Application by Highways England for an Order Granting Development Consent for the A303 Amesbury to Berwick Down

The Examining Authority's Second Written Questions and requests for information (ExQ2)

Environment Agency response to ExQ2 questions

MAP 1: Countess Channel and Bowles Hatches location

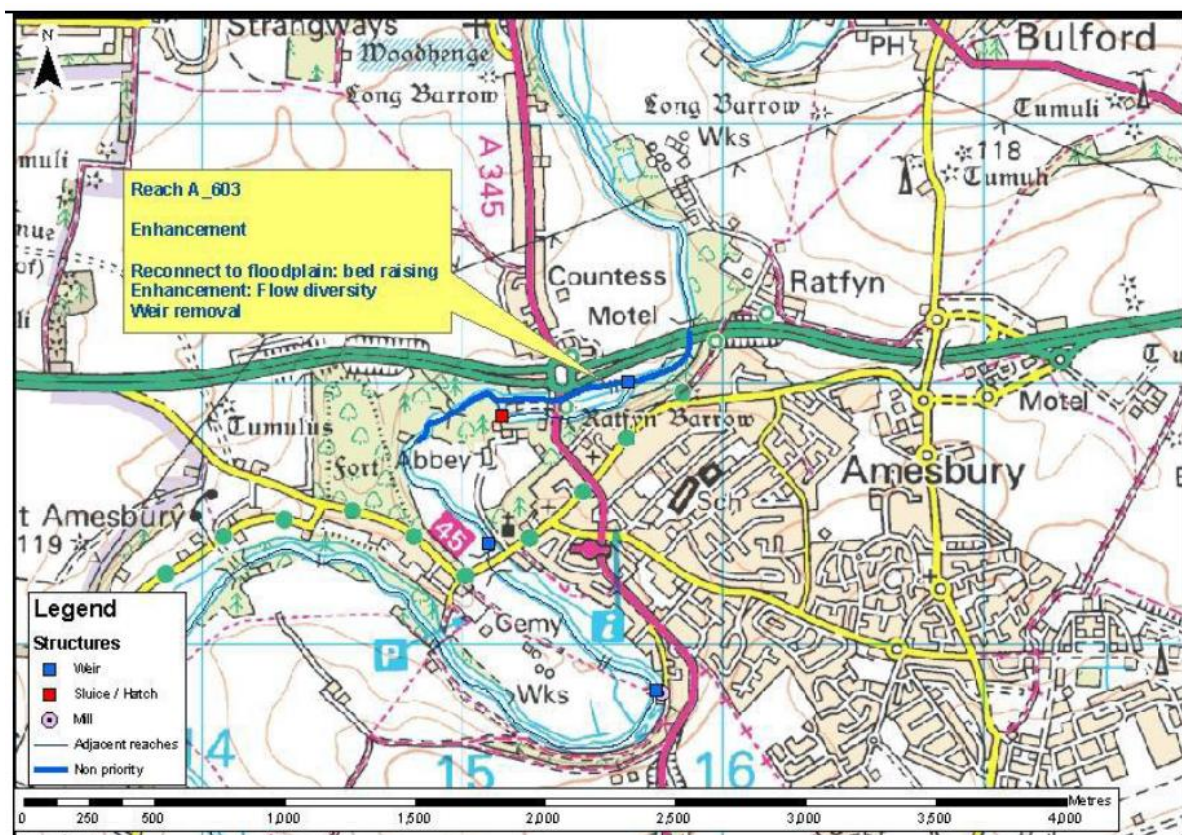
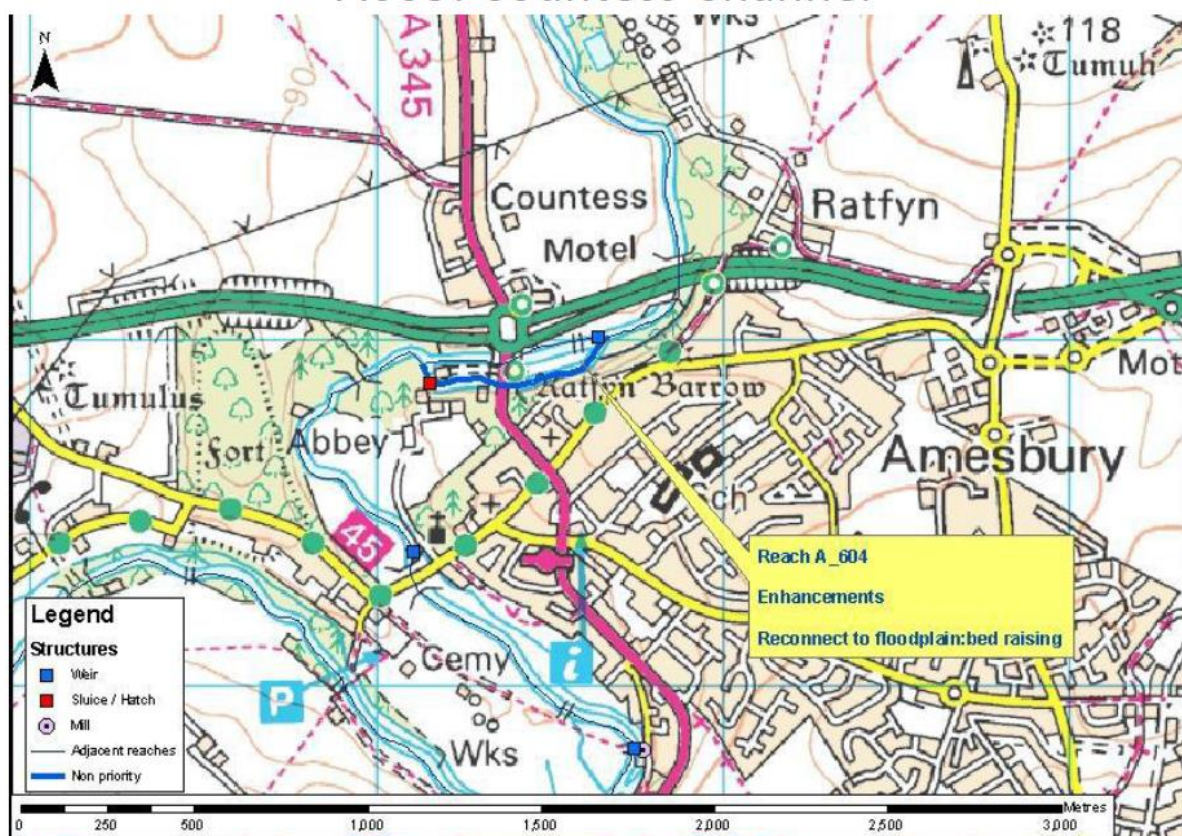
DCO.2. 68	Environment Agency	Additional Requirements Please indicate and explain further, with reference to relevant local and national policies on this topic, the contributions to improvements to waterbodies that could potentially be achieved as a result of the scheme and why it would be reasonable and necessary to secure this within the dDCO.	<p>As discussed in our previous written representations, we would recommend that a Requirement be included in the draft DCO relating to the need for an Environmental Enhancement Plan to be produced and submitted by the applicant. Alternatively we would be satisfied for the production of the plan to be included in the OEMP or HEMP. This could be included in the list of plans in OEMP reference MW-G7 and then the implementation/maintenance aspects covered in the HEMP as required.</p> <p>In terms of the contributions to improvements to waterbodies that could potentially be achieved as a result of the scheme, we can provide some specific examples, which are discussed below. These waterbodies have been impacted by previous road constructions and would benefit from being improved through the latest A303 Stonehenge road scheme.</p> <p>The Countess Channel and Bowles Hatches example provided below was submitted for the Environment Designation funding bid for 2019/20 but has currently been deferred. We understand the applicant may be relying on the Environment Designated Funds to address our concerns that the A303 Stonehenge scheme is lacking in environmental enhancement relating to the water environment. However, to date we do not have agreement for any proposals in the River Avon or River Till catchments relating to the Highways England Environment Designated funds. We therefore seek more certainty in delivering environmental enhancements that are required in these catchments, which we believe could be achieved in the production and implementation of an Environmental Enhancement Plan as part of the dDCO.</p> <p>Countess Channel and Bowles Hatches are located on the River Avon on the northern edge of Amesbury, very close to the proposed A303 Stonehenge road scheme. Please see the attached map (Map 1). These reaches of the Upper</p>

ExQ2	Question to:	Question	EA response 26 July 2019
			<p>Avon are part of the River Avon Restoration Plan. The reaches are part of SSSI unit 4 which is in unfavourable condition for inappropriate water levels, inappropriate modification of the channel form, physical processes and siltation.</p> <p>The river has been modified repeatedly through history and now has a rather complex layout. The key structures here are a weir which feeds flow toward the Countess channel, Bowles Hatches, three modern road bridges and one historic (disused) road bridge. The historic alignment of the River Avon can be inferred from examining LiDAR topographic data in conjunction with historic mapping dating back to 1879. It appears that a “double dog leg” bend upstream was removed when the A303 was built, in the 1960s. This presumably allowed the bridge to be built in the dry, on slightly higher ground, and the river was then diverted to flow under the bridge in a new excavation.</p> <p>The original channel remained downstream of the bridge and its upper end now forms the highway toe drain. Fish passage is currently impeded by Bowles hatches and the Countess weir.</p> <p>The primary restoration objectives for this reach are to remove the restriction to fish passage caused by the weir and the hatches and to improve the physical condition and habitat of the river channels. This will help towards improving the target condition, which is currently ‘unfavourable’, of the SSSI/SAC.</p> <p>The preferred option for this reach is to regrade the channel around the weir and reinstate the majority of the flow in the Countess channel, while leaving enough flow along the hatches feeder to maintain a healthy watercourse. This will create a more sustainable river system by reinstating a naturally functioning river channel which would adapt naturally to flood flows. This would improve drainage and preventing silt build up behind structures and within drainage channels, which potentially could impact the road network.</p> <p>This project will help natural sediment transport along the river whilst also benefiting the designated species and habitats currently not present along this reach of the River Avon.</p> <p>In 2014 the Environment Agency undertook appraisal, consultation (with landowners and fishing clubs) and drew up outline designs for this work; however, this project has not been progressed due to the complexity of the site and resources pressures within the programme. There is currently no secured funding</p>

ExQ2	Question to:	Question	EA response 26 July 2019
			<p>for this work but our delivery partners are keen to progress this project if resources are available to do so. Highways England will be a key partner in this project due to the close vicinity of the A303 and their road drainage networks. This project was submitted for the Environment Designation funding bid for 2019/20 but has currently been deferred.</p> <p>The Countess Channel and Bowles Hatches proposals, as well as others in the River Avon and River Till catchments that are currently less worked up, would contribute to restoration of the rivers Avon and Till (both SAC and in unfavourable condition) which the A303 currently crosses and additional crossing proposed. We can provide more detail on the river restoration proposals if required.</p> <p>There is <u>no commitment within the current A303 Stonehenge road scheme</u> to directly enhance the area nor take advantage of existing partnership opportunities that may contribute to overall net gain and achieve multiple benefits.</p> <p>Multiple benefits could be achieved by contributing to climate change resilience, potential air quality/noise benefits from any increased (wet) woodland, wellbeing and recreational benefits from angling and other public opportunities, not least alongside species and habitat improvements from improved morphology.</p> <p>This would commit Highways England to explore and utilise the opportunities within the Hampshire Avon Catchment Partnership to deliver the River Avon Restoration Plan and its associated multiple benefits.</p> <p>Local and National policies There are government aspirations for river restoration, net gain, partnership working and multiple benefits. These include: Making Space for Nature, Biodiversity 2020: A Green Future: 25 Year Environment Plan; National Planning Policy Framework (NPPF); SW River Basin Management Plan; and the River Avon Salmon Action Plan.</p> <p>In particular we would reference the recent Biodiversity Net Gain good practice guidance as published by CIEEM and CIRIA (and 2019 government consultation), promoting:</p> <ul style="list-style-type: none"> ○ Being inclusive, equitable, sharing benefits amongst stakeholders; ○ Being additional to achieve conservation outcomes that demonstrably exceed existing obligations;
